City of Albuquerque SWPPP Inspection Checklist

| Date of Inspection: | 8/2/23 | Contact Email: | 1 |

ENGINEER'S SEAL RONALD R. BOHANNAN NEW MEXICO PROFESSIONAL ENGINEER 7868 4-17-23 RONALD R. BOHANNAN P.E. #7868	3831 MASTHEAD ST ALBUQUERQUE, NM	DRAWN BY pm
EROSION CONTROL PLAN		DATE 4-17-23
		DRAWING
		SHEET # SW-1
		JOB # 2022002

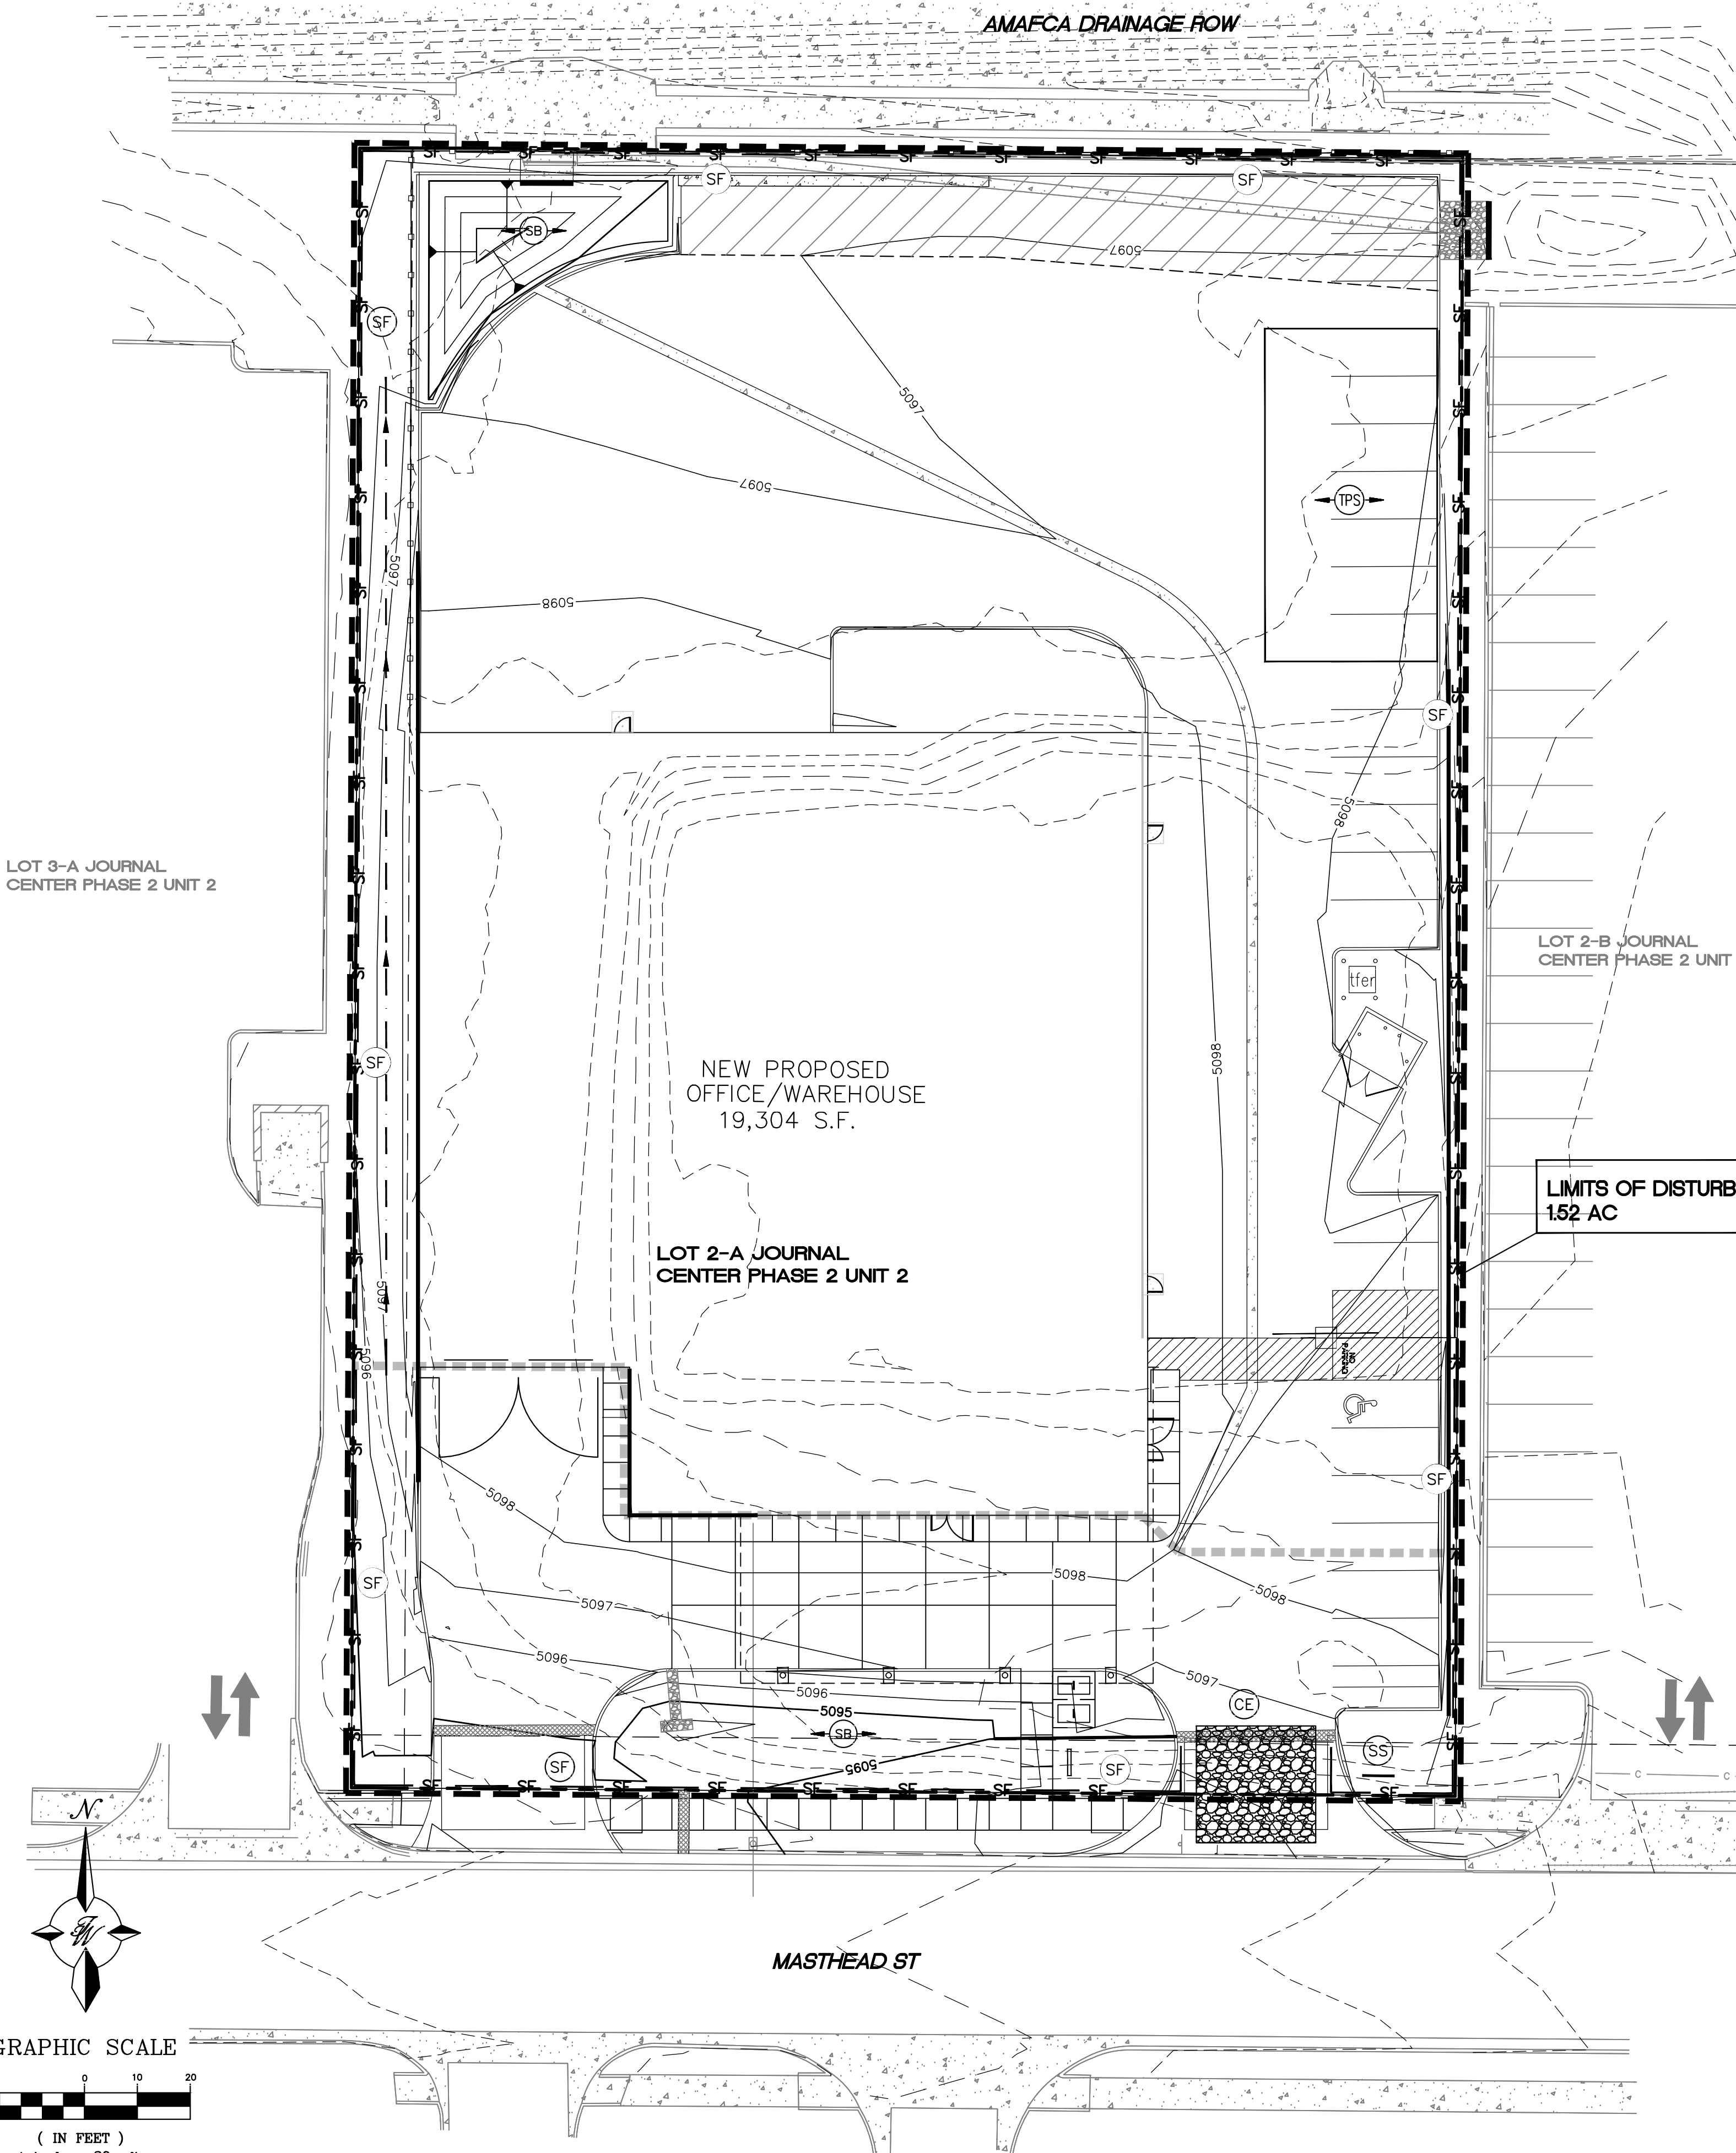
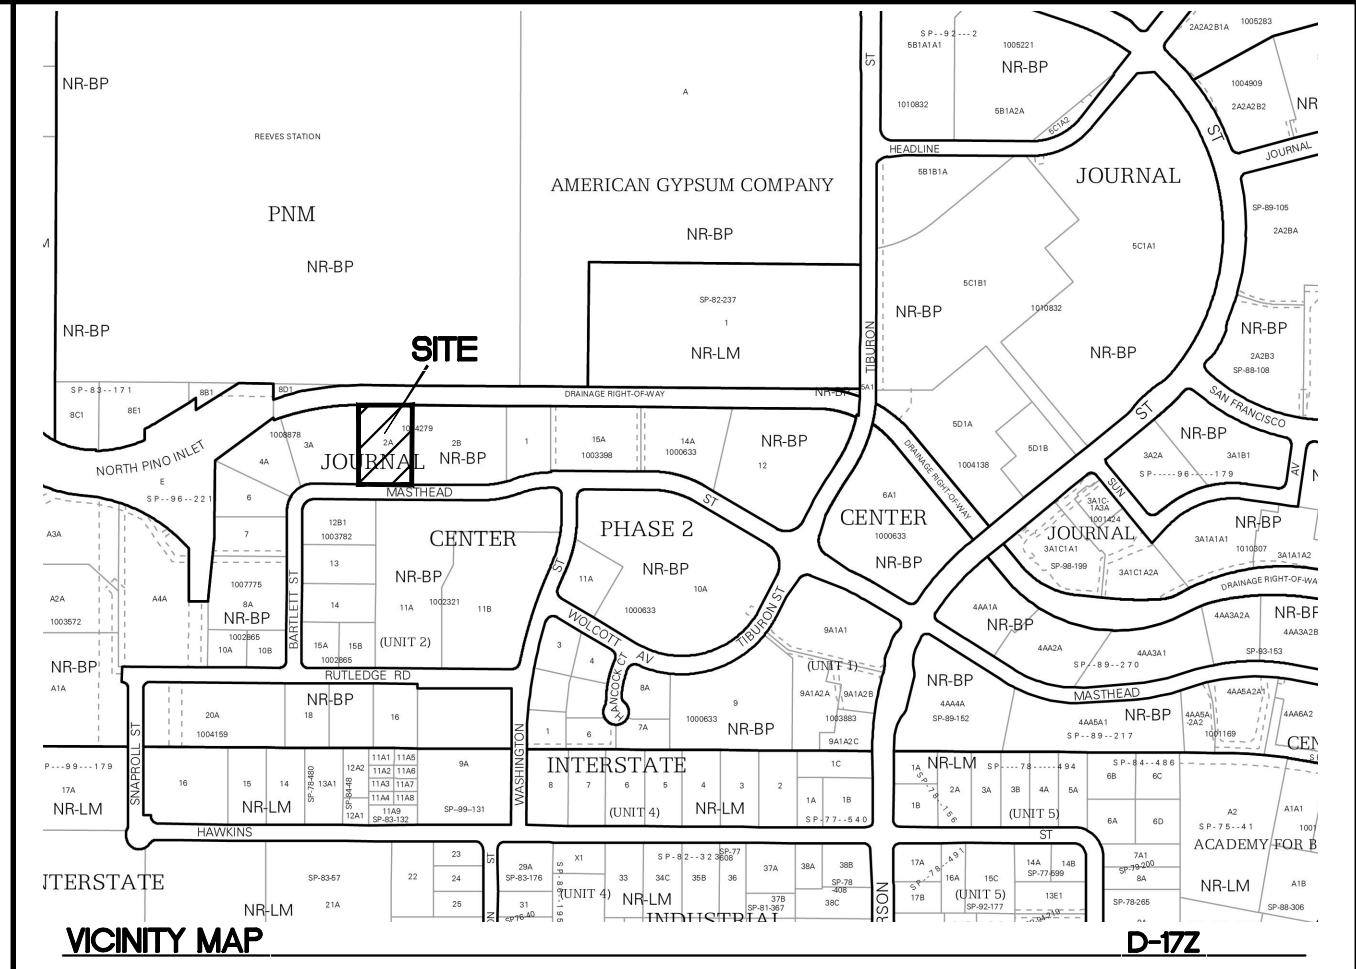
| SWPPP Requirements | CGP (SWPPP) | YES | NO | COMMENTS |
|--|-----------------------------|-------------------------------------|-------------------------------------|--|
| SWPPP modifications must be recertified by operators. | 7.4.2, 7.4.3 I.11.4 (App F) | <input type="checkbox"/> | <input type="checkbox"/> | Modify Entrance? |
